HERTFORDSHIRE FIRE & RESCUE SERVICE
Fire Protection

Comet Group plc Unit 1, Oldings Corner, Comet Way, Hatfield, Hertfordshire, AL9 5JY

Thank you for your letter dated 6th September 2016, enclosing a copy of the Planning Application and drawing number **6/2016/1739/MAJ** in respect of the above premises.

We have examined the drawing and note that the provision for **Hydrants and Access** does not appear to be adequate to comply with BS9999:2008.

Proposed Student Residential
Studio rooms = 66
Twodio = 12

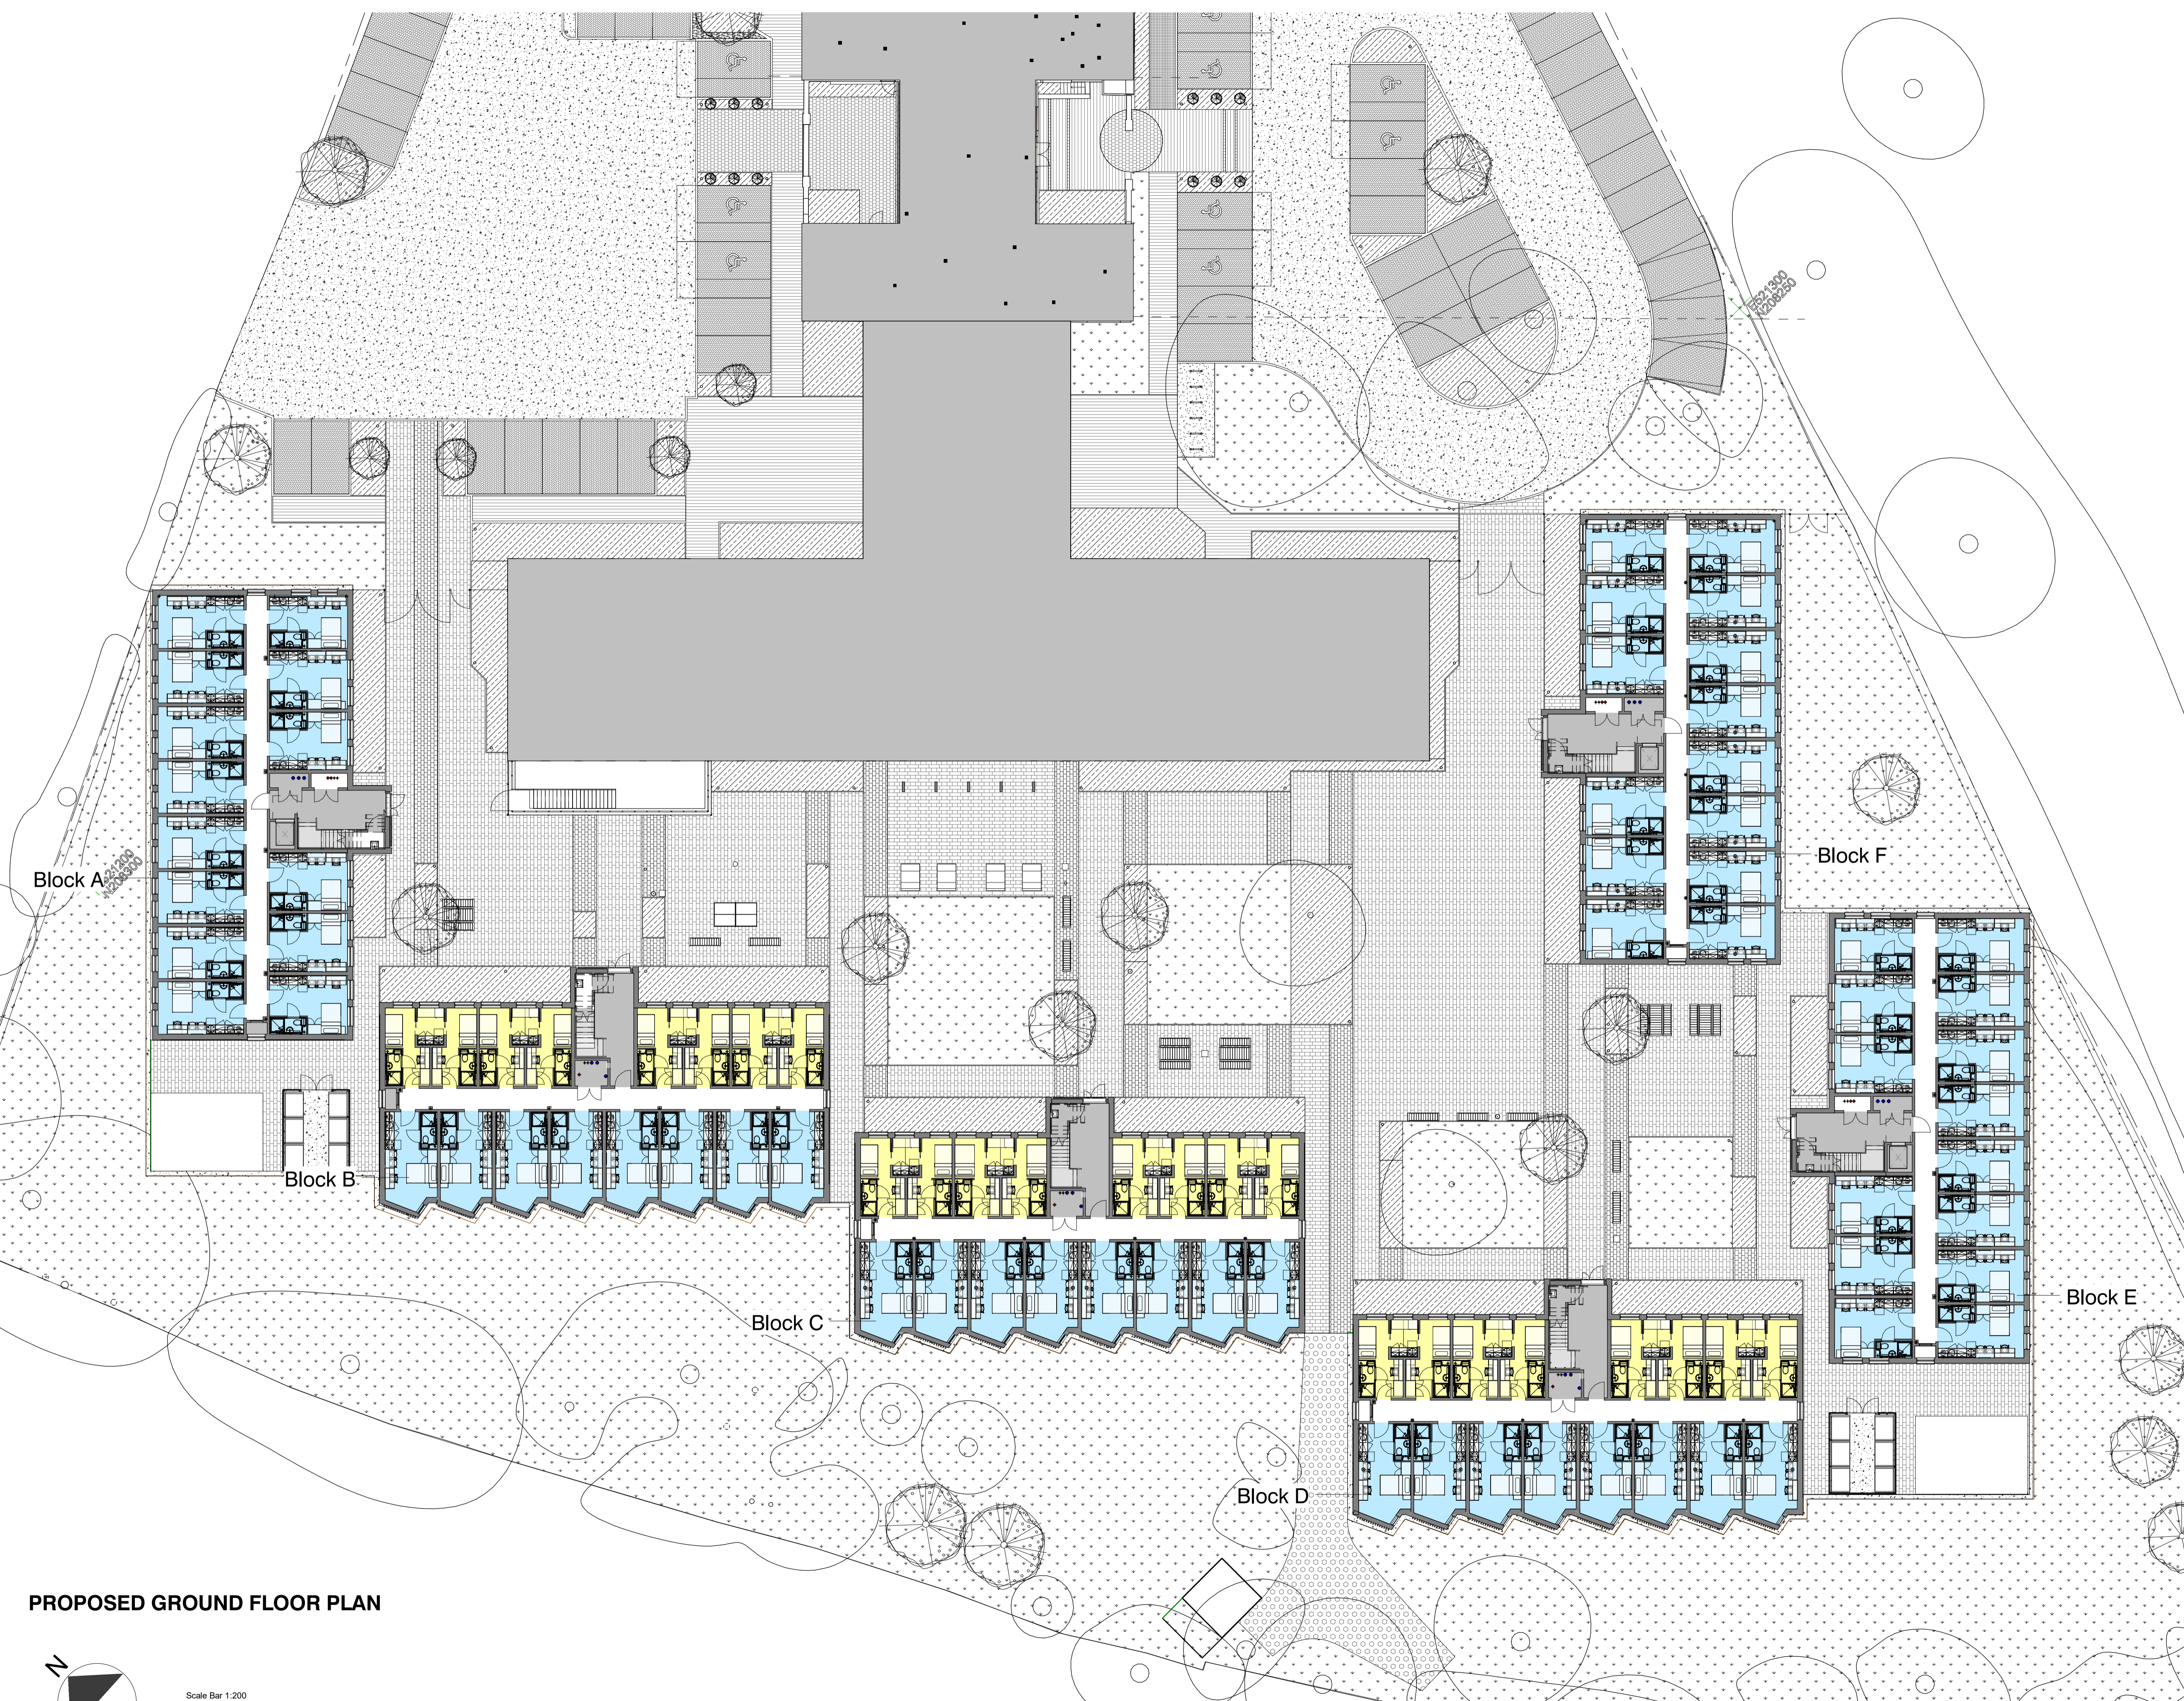
1. Access for fire fighting vehicles should be in accordance with The Building Regulations 2000 Approved Document B (ADB), section B5, sub-section 16.
2. Access routes for Hertfordshire Fire and Rescue Service vehicles should achieve a minimum carrying capacity of 18 tonnes.
3. Turning facilities should be provided in any dead-end route that is more than 20m long. This can be achieved by a hammer head or a turning circle designed on the basis of Table 20 in section B5.

5. This authority would consider the following hydrant provision adequate:
 - Not more than 60m from an entry to any building on the site.
 - Not more than 120m apart for residential developments or 90m apart for commercial developments.
 - Preferably immediately adjacent to roadways or hard-standing facilities provided for fire service appliances.
 - Not less than 6m from the building or risk so that they remain usable during a fire.
 - Hydrants should be provided in accordance with BS 750 and be capable of providing an appropriate flow in accordance with National Guidance documents.
 - Where no piped water is available, or there is insufficient pressure and flow in the water main, or an alternative arrangement is proposed, the alternative source of supply should be provided in accordance with ADB Vol 2, Section B5, Sub section 15.8.

6. In addition, buildings fitted with fire mains must have a suitable hydrant sited within 18m of the hard standing facility provided for the fire service pumping appliance.
